**Recommendation:** Refuse

**Proposal:** Erection of a 4 bedroom detached dwelling with garage and access

**PROPOSED FLOOR PLANS**

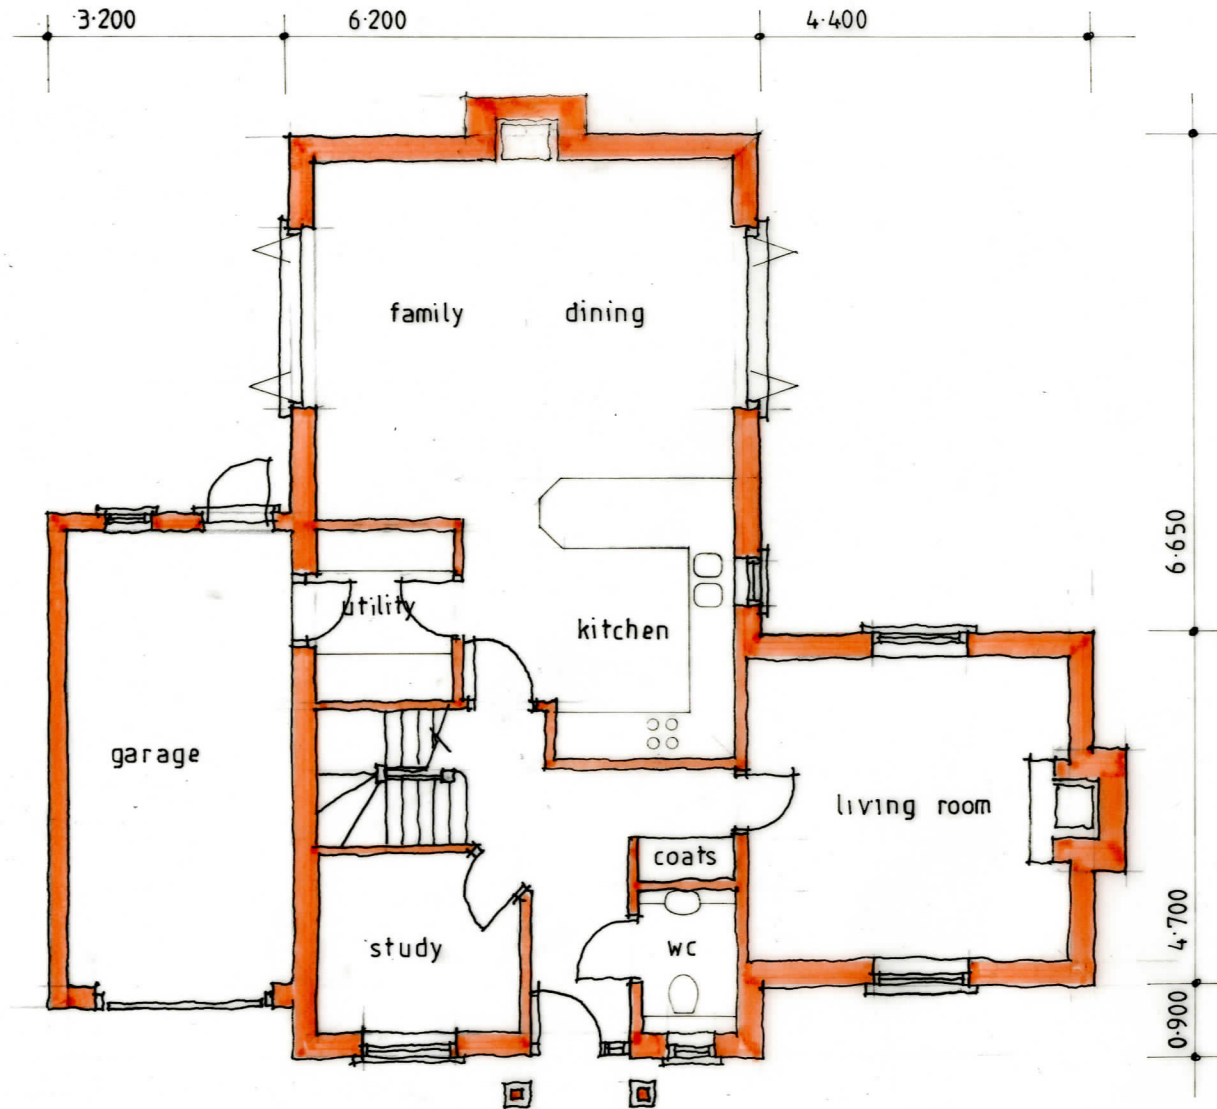
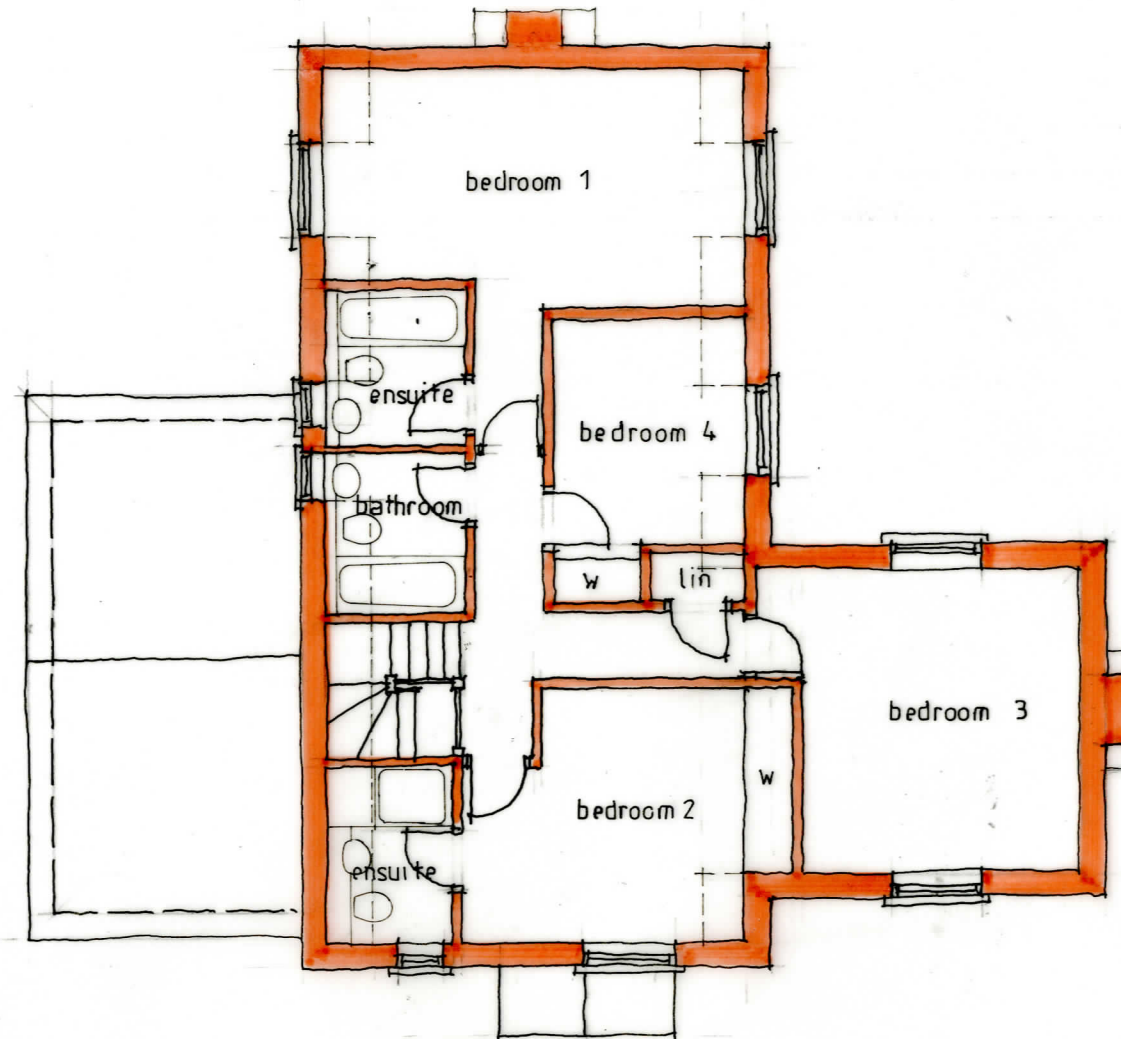
- 8.22. Turning to the design and appearance of the dwelling; the previous dismissed appeal showed a modest linear dwelling, centrally within the site. The current proposal seeks a larger and more suburban style of dwelling, but within a relatively small plot. Officers consider that it would not assimilate well into the street scene or reflect the character of the neighbouring dwellings, where dwellings are either of a more simple, linear historic form, or (where dwellings are of a similar scale to that proposed here) are afforded larger plots. Thus, and further to the previous decision, officers consider that the design and scale of the dwelling is inappropriate to the local setting and would cause harm in this respect.
